UPDATE TO OXFORDSHIRE COUNTY COUNCIL'S RESPONSE TO CONSULTATION ON THE FOLLOWING DEVELOPMENT PROPOSAL

Application No: 17/02534/OUT-3

Proposal: OUTLINE - The construction of a business park of up to 60,000 sq.m (GEA) of flexible Class B1(a) office / Class B1(b) research & development floorspace; parking for up to 2,000 cars; and associated highways, infrastructure and earthworks

Location: Land North Of Bicester Avenue, Garden Centre, Oxford Road, Bicester.

**Scenario 1: '2026 PM BTM + Committed + 60k'** (FG17: '2026 PM BTM + Committed + 60k', Plan 1: 'Control Plan')  
**Network Layout Diagram**

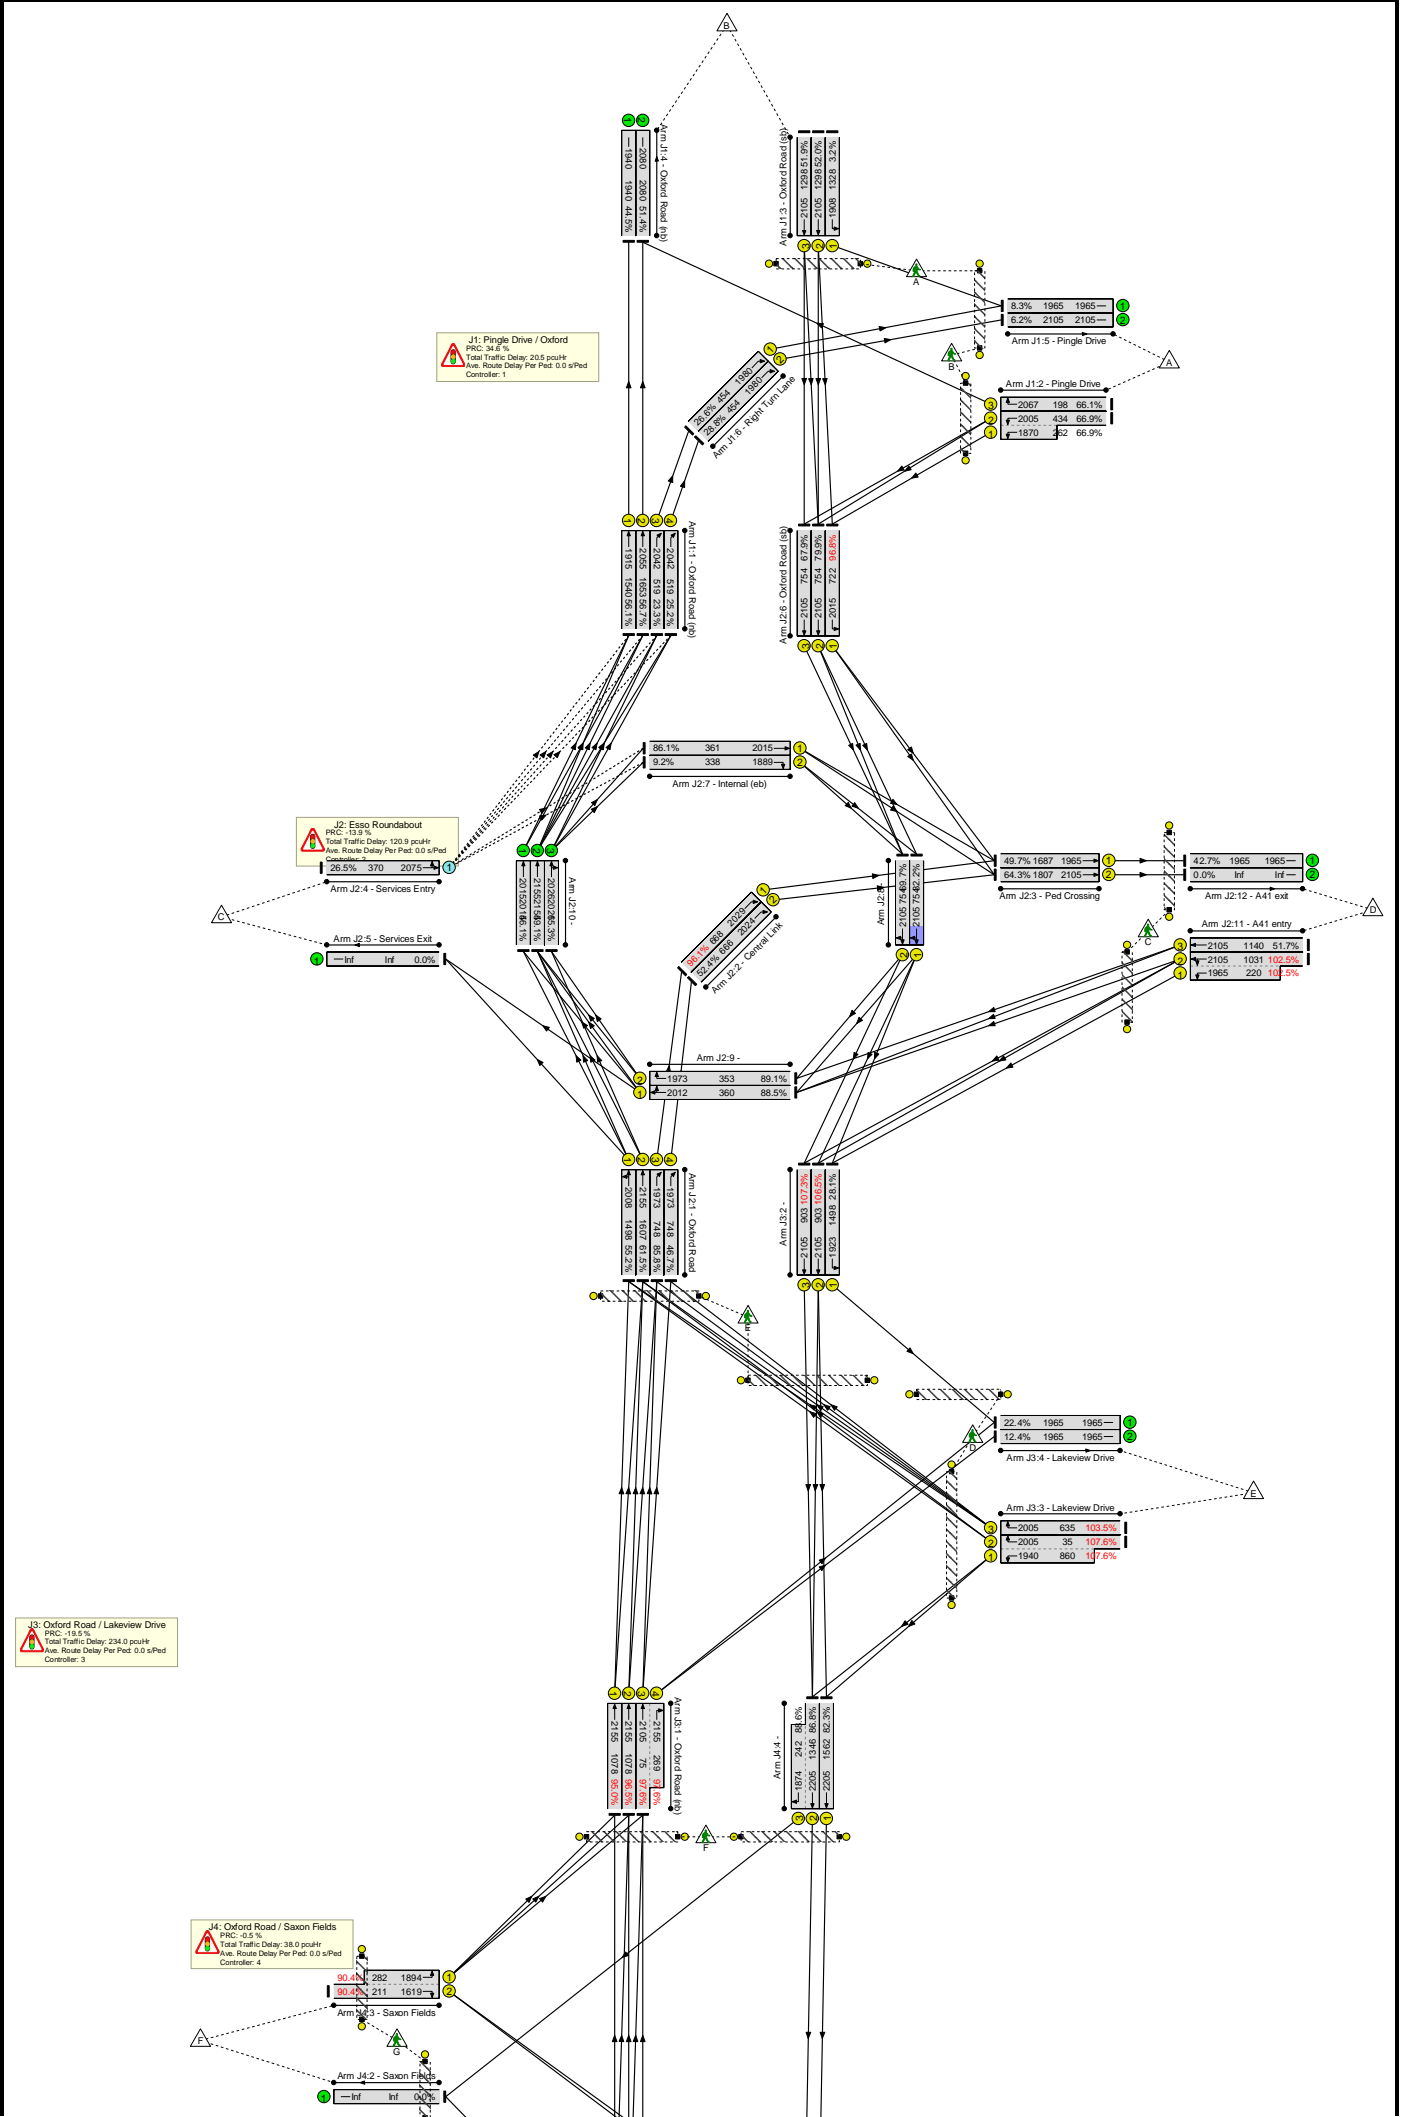
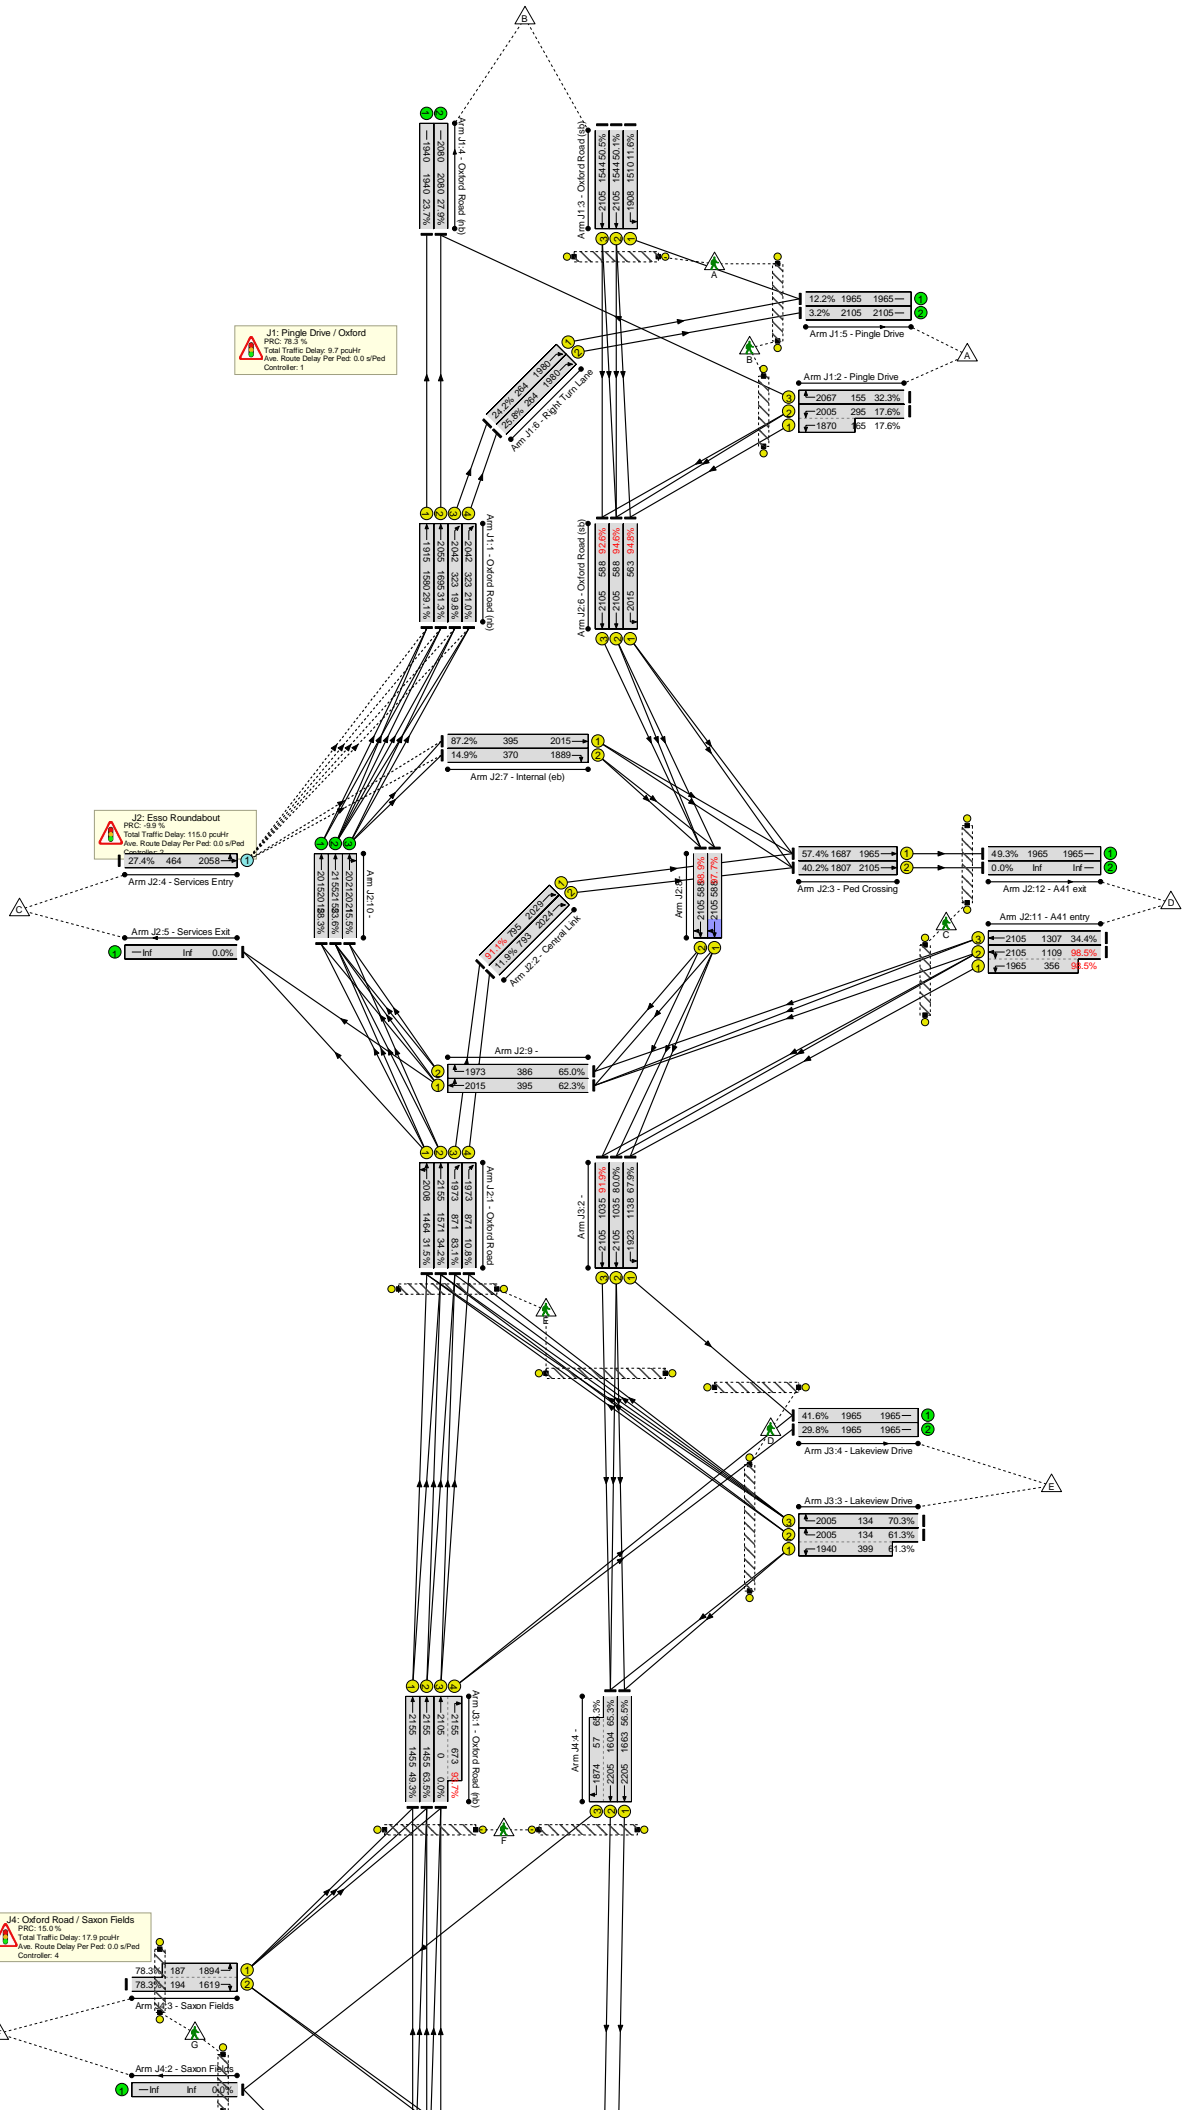
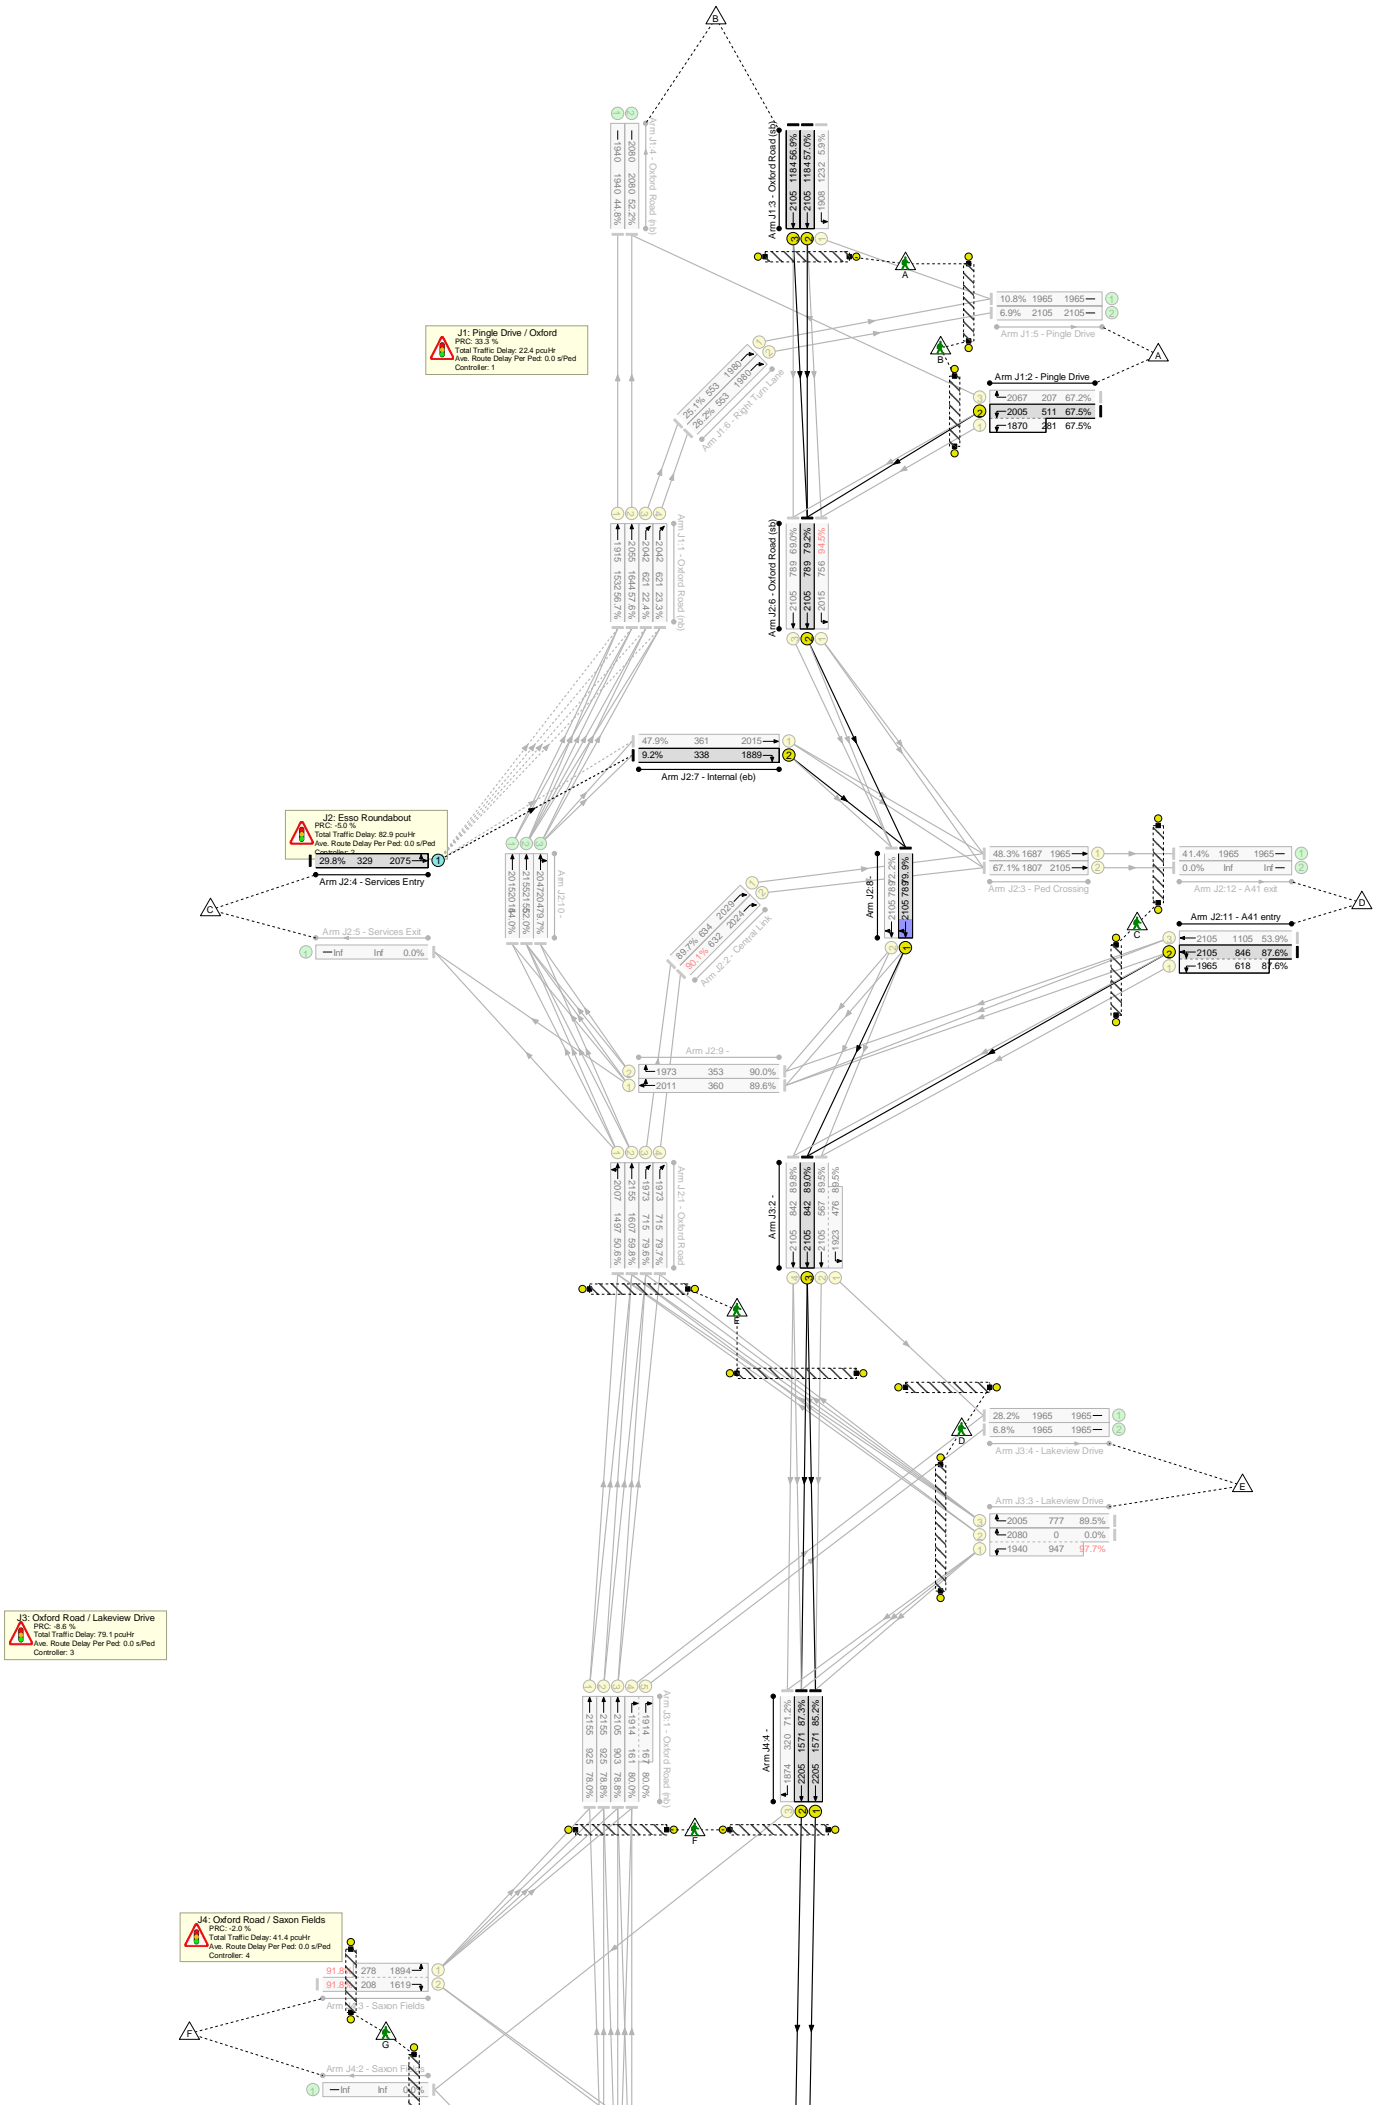
- The services entry arm (from the Esso filling station and Burger King) on the Esso Junction is a give way lane represented as J2:4/1. This arm has been incorrectly configured as having no opposing lanes – which gives an unrealistically high capacity for this approach

- Matrix estimation indicates that not all turning counts have been entered. Looking at the PM demand flow for the same approach arm (services entry arm of Esso Roundabout), only 98 pcu's were modelled instead of 127pcu's. It is thought that if matrix estimation is being used, this should be completed.

- Lane widths used in the model are incorrect. Where it has been possible to measure lane widths from scale plans, the lane widths used in the calculation of saturation flow appear to be consistently wider than the measured lane widths. This probably won't make much difference to the results (the relative increase in capacity should be the same), as it is incorrect in both the base and proposed models. This however will result in an over optimistic calculation of saturation flows in both models.

- Saturation flows have shown to be generally higher than would normally be. This causes traffic capacity to be over-estimated. Where there is only one lane serving any given destination, the lane should be treated as a nearside lane in the saturation flow calculations. This is because slow vehicles will delay the entire route flow, unlike multiple lane / route choice approaches, where faster vehicles are able to overtake in the offside lane.

- The Oxford Road northbound stream (exit arm) of Pingle Drive/Oxford Road junction (presented as Arm J1:4 in the model) is shown without a pedestrian crossing across it, despite a signalled crossing across southbound. Presently, a pedestrian crossing goes across both the northbound and southbound traffic streams. This modelling inaccuracy is likely to create an artificially higher saturation across the junction.

- Use of lane connectors to allow weaving will allow overly optimistic distribution of traffic flows and allows inappropriate route selection. If/where lanes are not immediately available at the exit of the previous junction, intermediate exit lane lanes may be required to accurately model lane and route choices. Alternatively, route flows may need to be manually set to manage traffic flows on weaving connectors.
